**From:** Contact Centre (CRM) <contact@ribblevalley.gov.uk>  
**Sent:** 24 February 2026 11:40  
**To:** Planning  
**Subject:** Planning Application Comments - 3/2026/0086 FS-Case-802951714

**Planning Application Reference No.:** 3/2026/0086

**Address of Development:** THE SWAN AND ROYAL  
26 CASTLE STREET  
CLITHEROE  
BB7 2BX

Proposed East Elevation

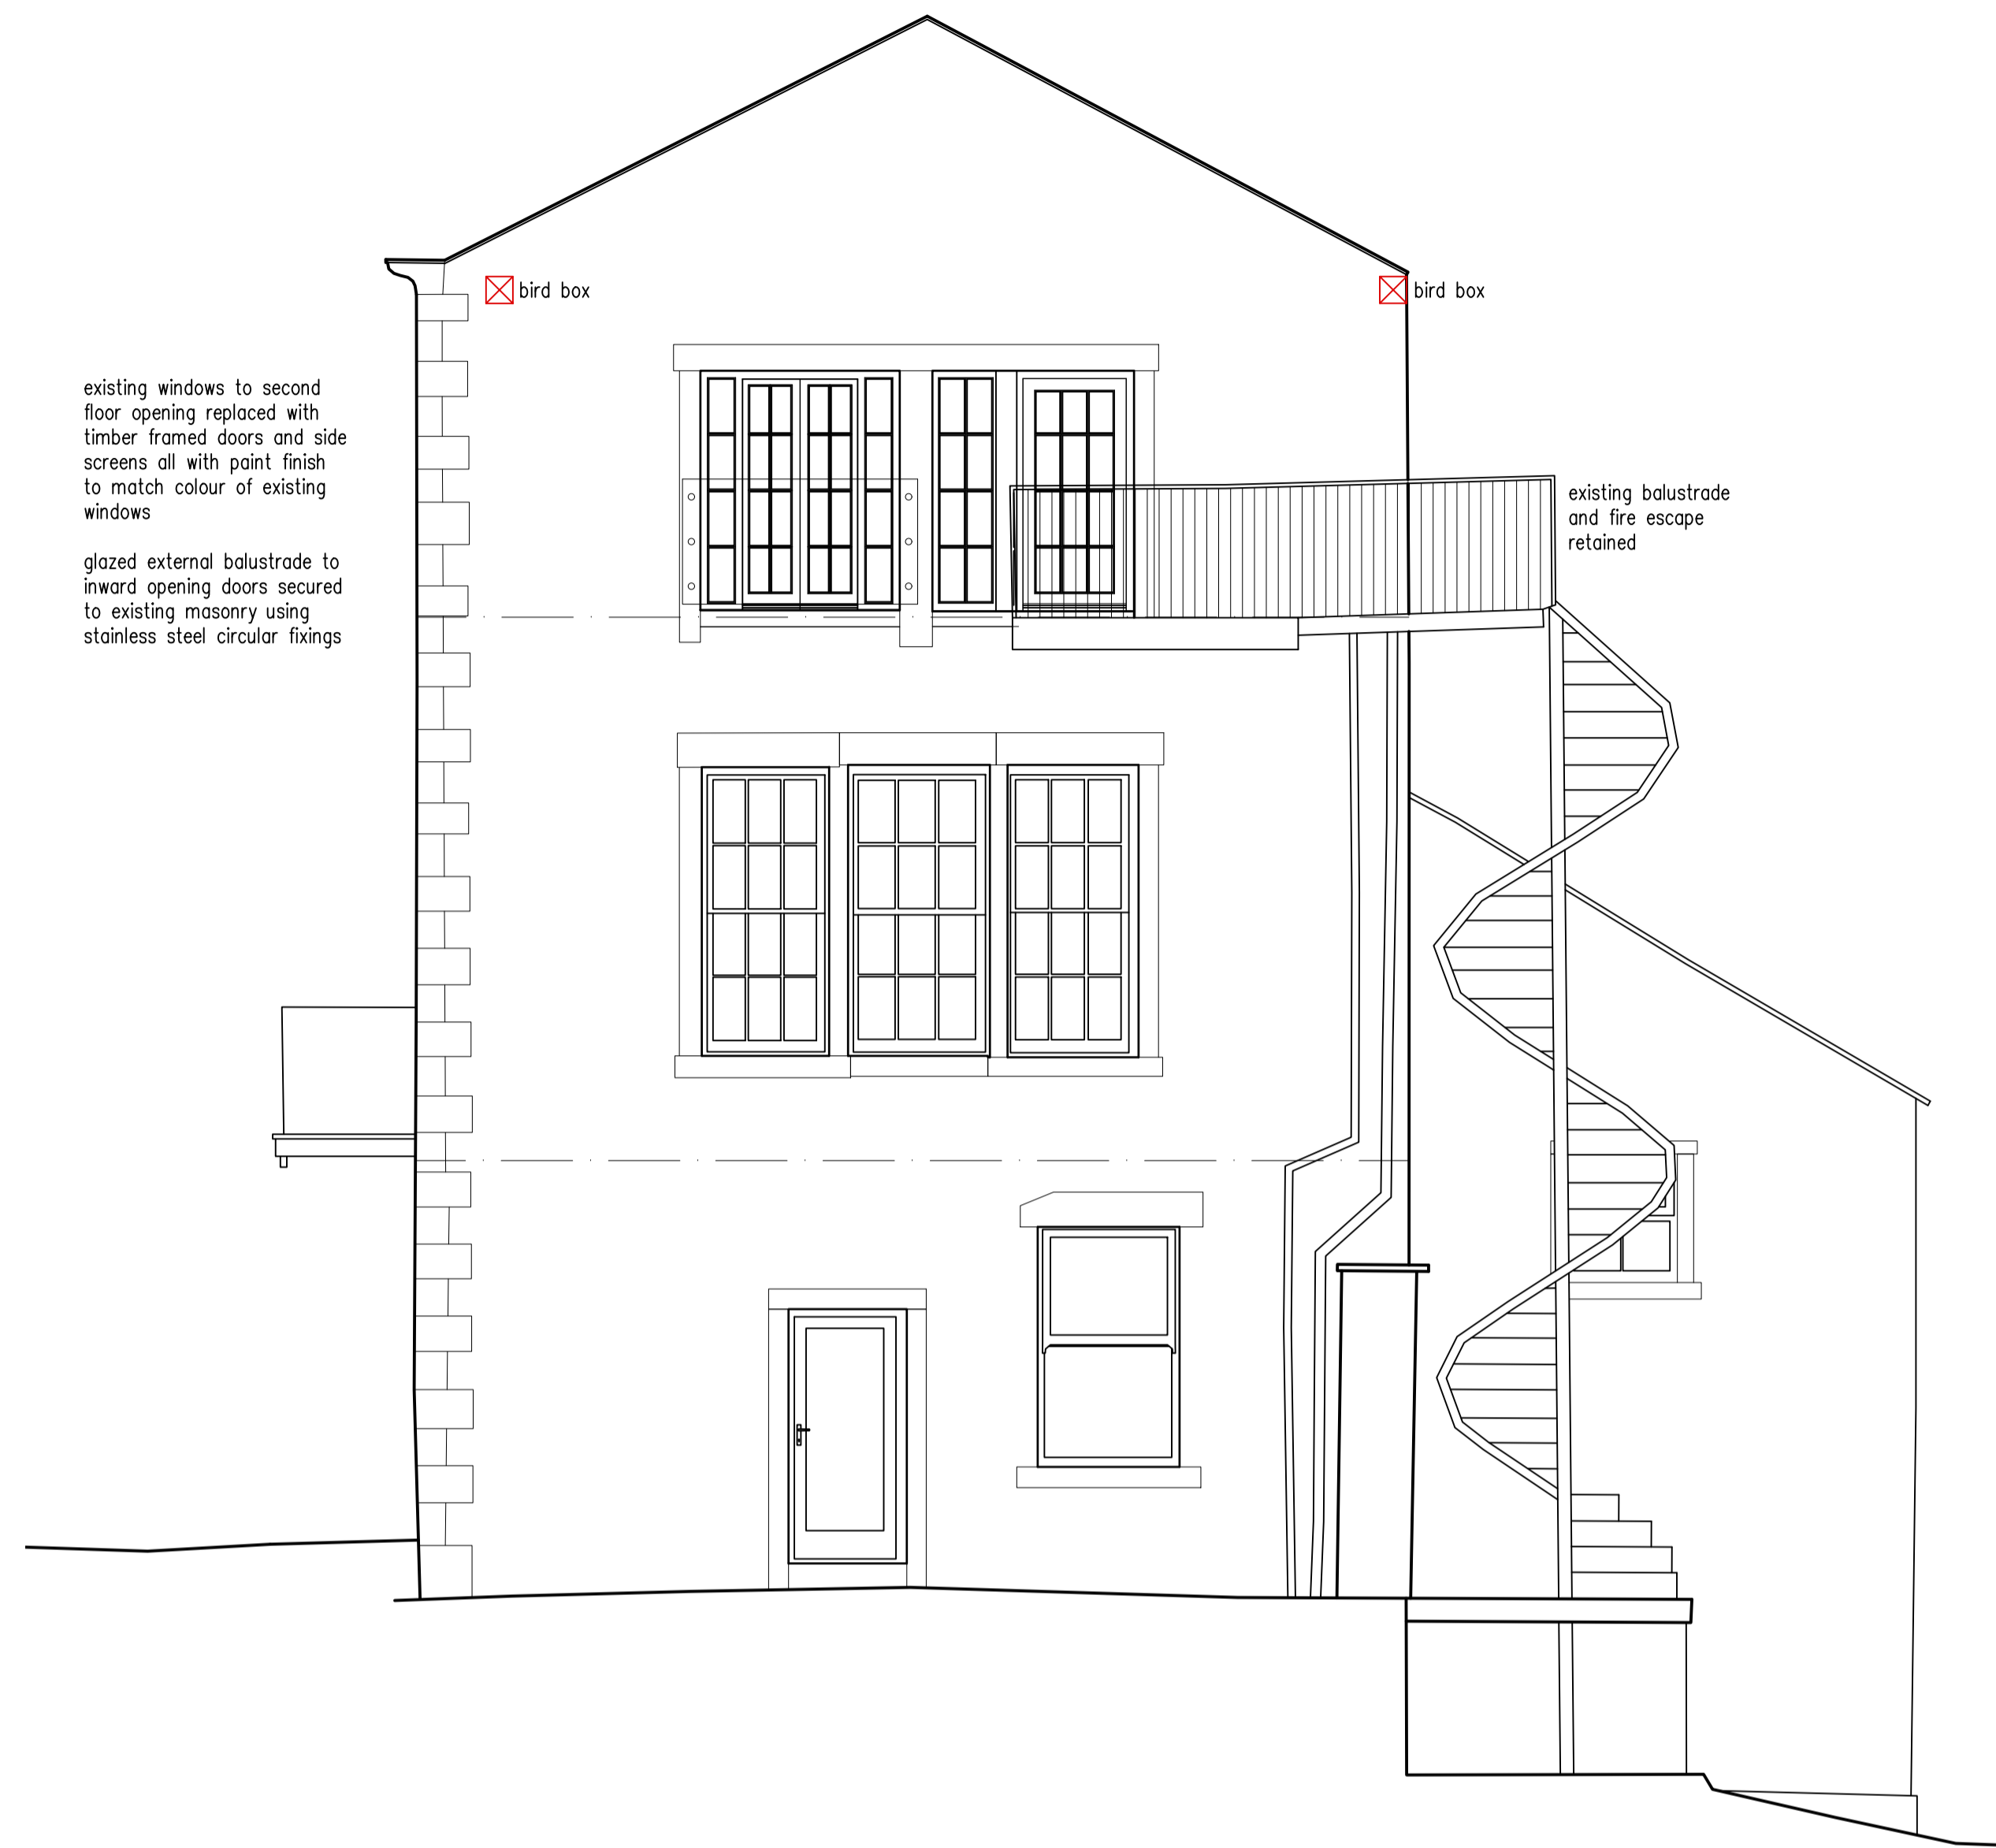
We welcome the proposals to use slim-line conservation glazing and timber window frames for the new windows and French doors on the eastern gable of the building. These are appropriate for use in a listed building and are in keeping with existing windows on the rear extension of the pub. The proposed glass balustrade would also be inobtrusive, and not harmful to the significance of the listed building or the conservation area.
